EAST LIMERICK SUBSTATION DEVELOPMENT

Road Safety Audit Stage 1/2

Project Title	Proposed Substation at East Limerick
Project No.	25232-02
Document Title	Road Safety Audit Stage 1/2
Document No.	25232-02-001

SUBSTATION ACCESS - EXISTING

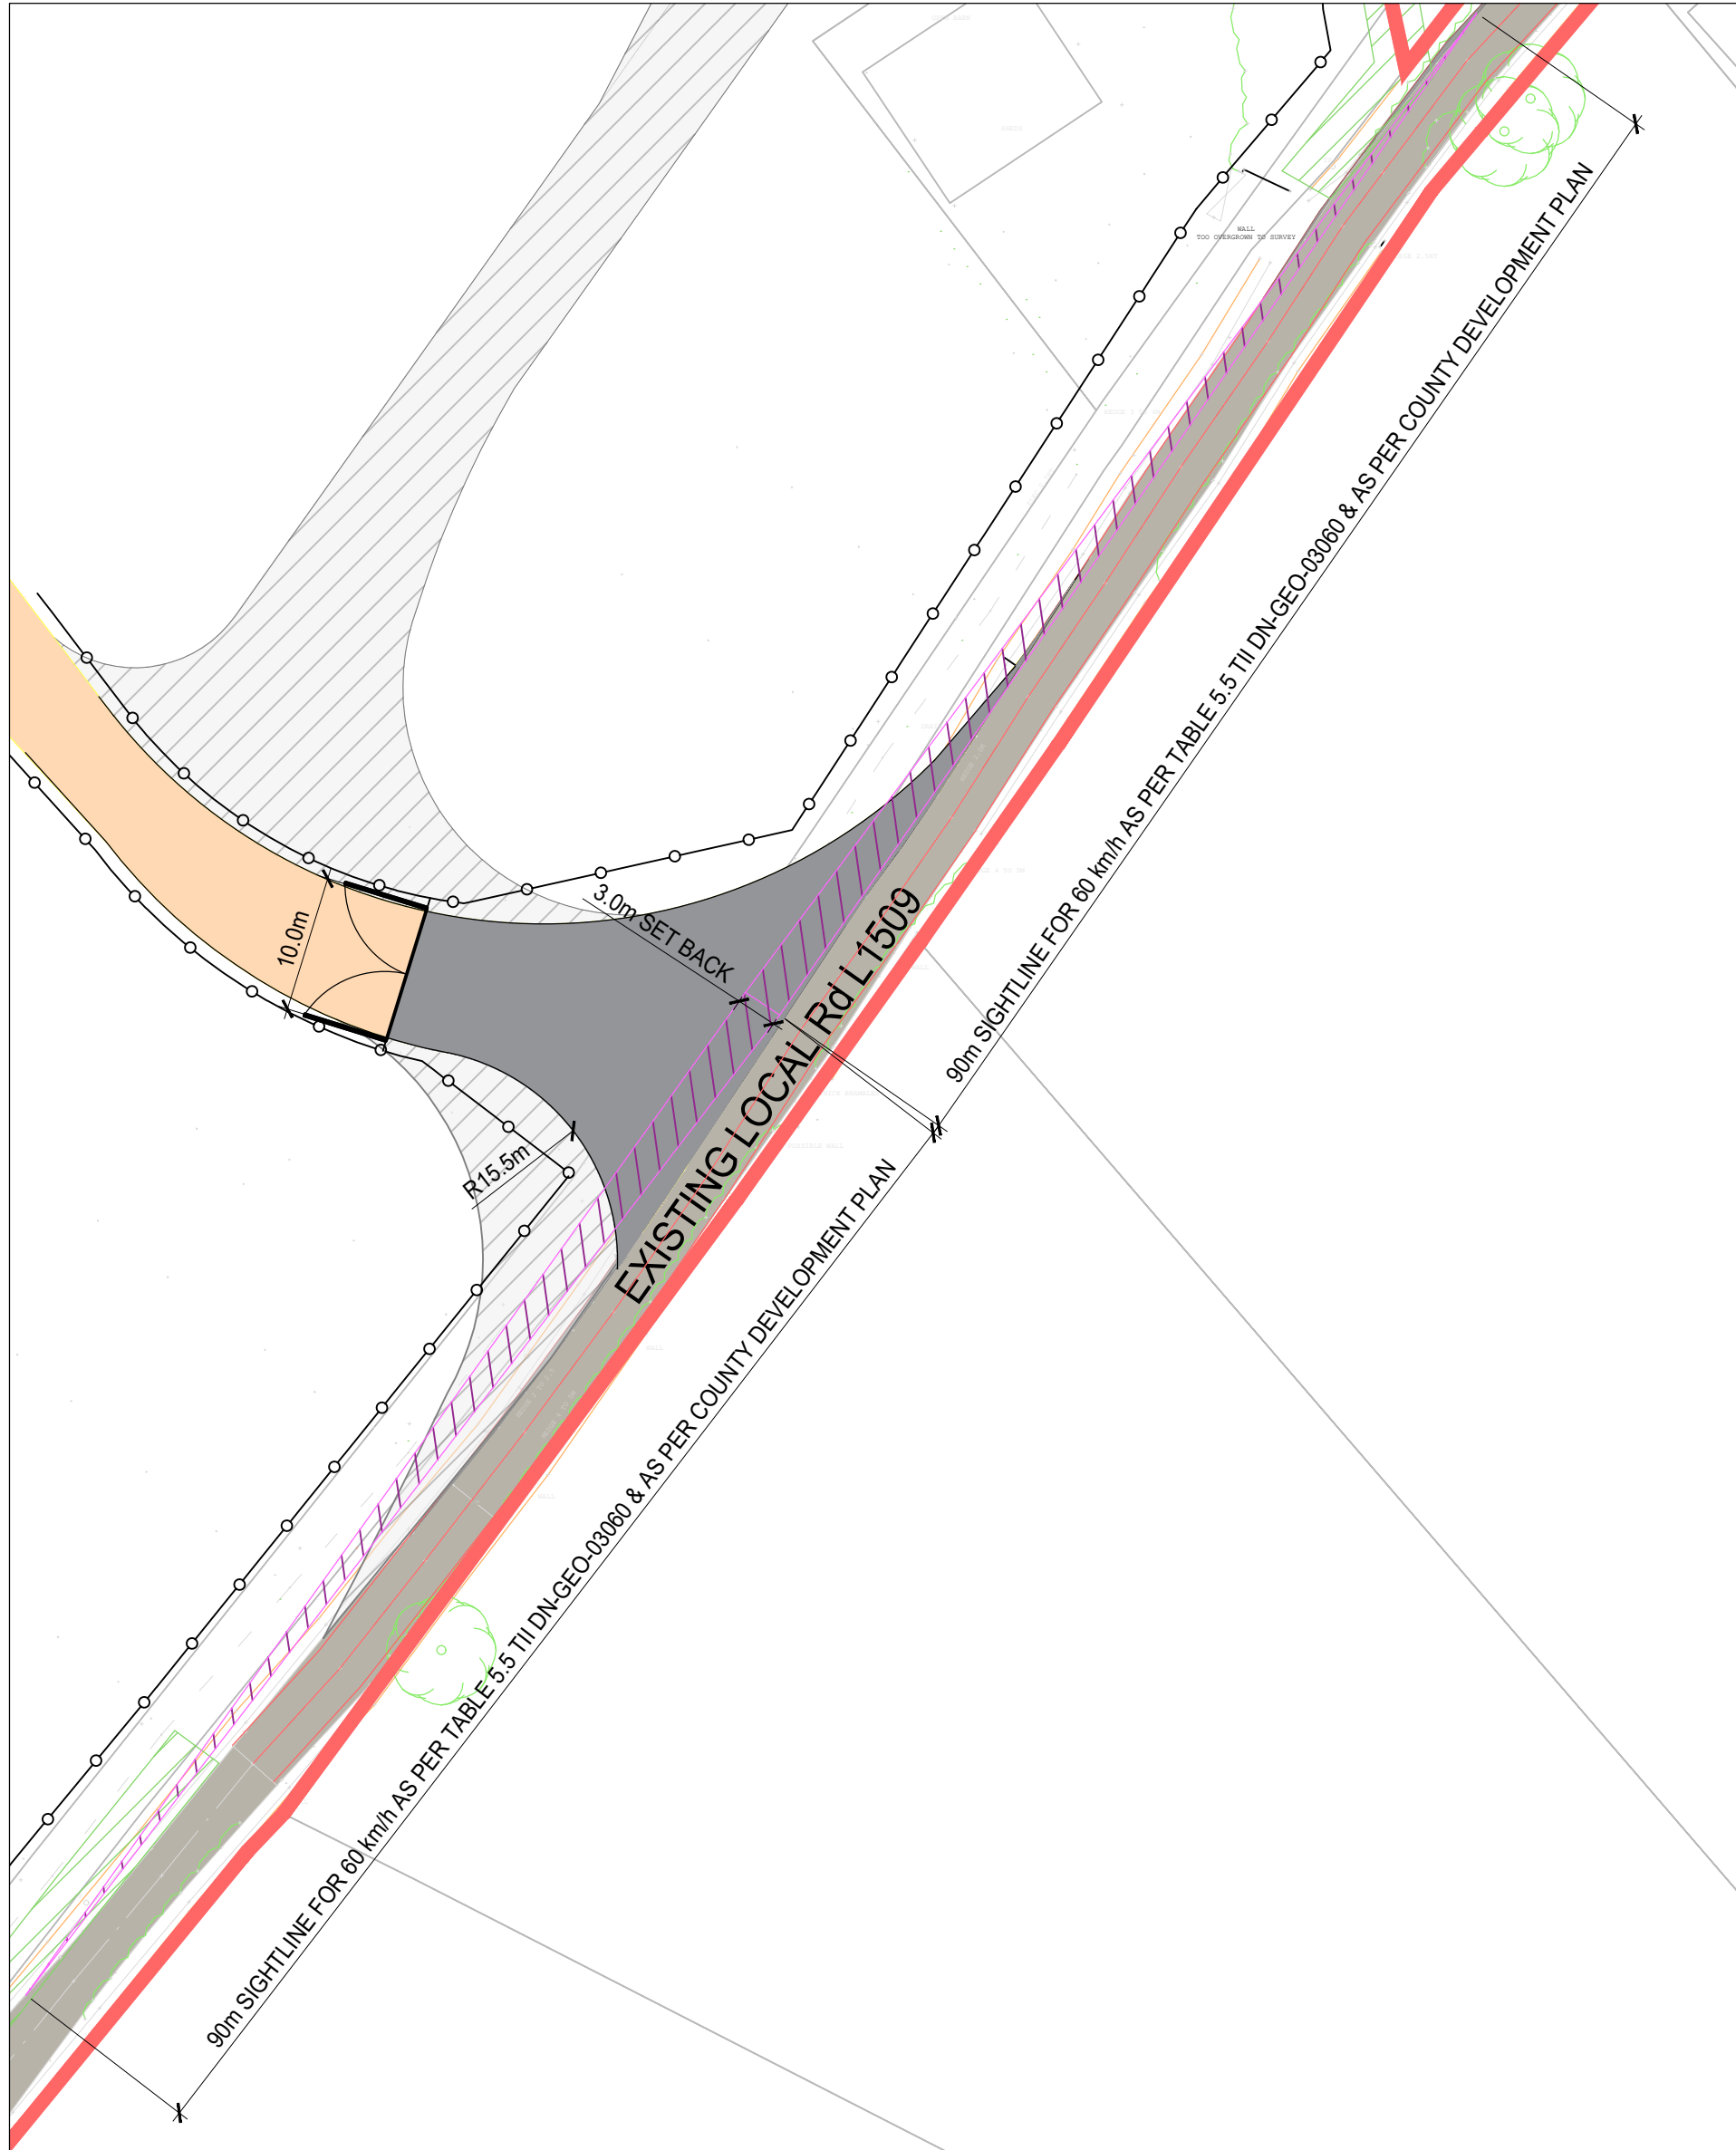
2.1 Problem: Skewed Angle

Location: Substation Access

The proposed development access intersects the local road at a skewed angle rather than at, or close to, a right angle. As a result, drivers exiting the development will be required to look back over their right shoulder to observe approaching traffic on the local road. This manoeuvre may reduce the effectiveness of driver observations and compromise intervisibility between exiting and approaching vehicles. Consequently, the likelihood of missed observations and vehicular conflicts may be increased.

Recommendation: Revise the alignment of the proposed development access to form a junction angle as close as practicable to 90 degrees with the local road.

1:500 @ A1

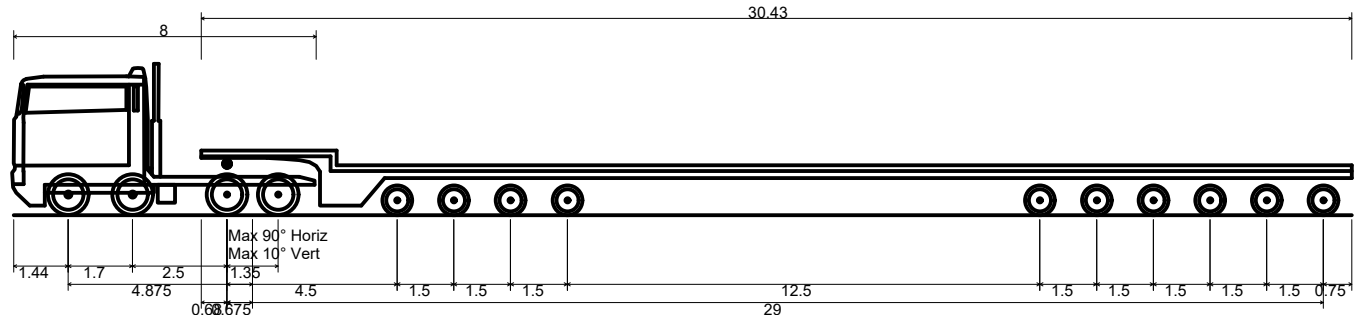
2.2 Problem: Vehicle Over-run

Location: R513/L1509 Junction

Swept path analysis indicates that the proposed delivery vehicle overruns the existing footpath and carriageway edge at the R513/L1509 junction during turning manoeuvres. As a result, pedestrians using the footpath may be at increased risk of conflict with turning vehicles. Repeated overrun of the footpath may also result in damage to the footway surface, potentially creating trip hazards for pedestrians. In addition, vehicle overrun of the carriageway edge may increase the risk of loss-of-control collisions and damage to the road infrastructure.

Recommendation: Review the junction layout and vehicle access arrangements to ensure that the design delivery vehicle can complete the required turning manoeuvres without overrunning the existing footpath or carriageway edge. Where this cannot be achieved, appropriate measures should be provided to mitigate the risk to pedestrians and other road users.

Paragraph No. in Safety Audit Report	To Be Completed By Designer			To Be Completed by Audit Team Leader
	Problem accepted (yes/no)	Recommended measure Accepted (yes/no)	Describe alternative measure(s). Give reasons for not accepting recommended measure. Only complete if recommended measure is not accepted.	Alternative measures or reasons accepted by auditors (yes/no)
2.1	Yes	Yes. The access has been revised to form a junction angle of 70 degrees as per DN-GEO-03060. This provides a less skewed junction angle, while still facilitating the vehicle movements associated with the transformer delivery. This is shown on drawing no. 251014-SS-X-X-XXX-DR-CE-1200.		
2.2	Yes	Yes. The drawing has been updated to show temporary road widening measures to facilitate the vehicle movements associated with the substation delivery. This is shown on drawing no. 251014-SS-X-X-XXX-DR-CE-1201.
